**SSD 9813: MIXED USE DEVELOPMENT (GOSFORD ALIVE ON KIBBLEPLEX SITE)
136-146 & 148 DONNISON STREET GOSFORD**

Transport for NSW have reviewed the Environmental Impact Assessment prepared by Mecone and dated 27 September 2019 and the Transport Impact Assessment (TIA) prepared by GTA Consultants and dated 22 August 2019, and provide the following comments:

Figure 8.1: AM (PM) [Sat] peak hour site generated traffic volumes

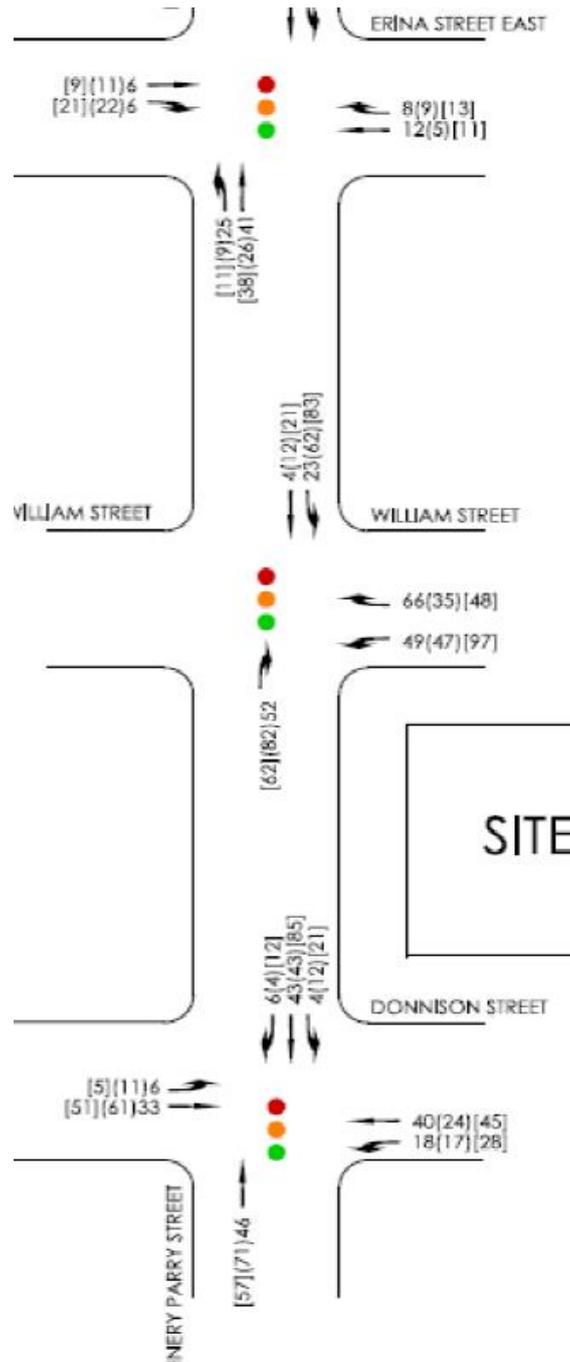
- The report details which development access point vehicles are expected to use, however, it does not detail where these vehicles are approaching from. It appears from Figure 8.1 that the majority of vehicles are approaching from the east, with minimal traffic coming from the west. However, there appears to be significant development to the west, including industrial, retail and an entertainment ground and other significant employment generators. Clarification is required for the trip distribution assumptions used.
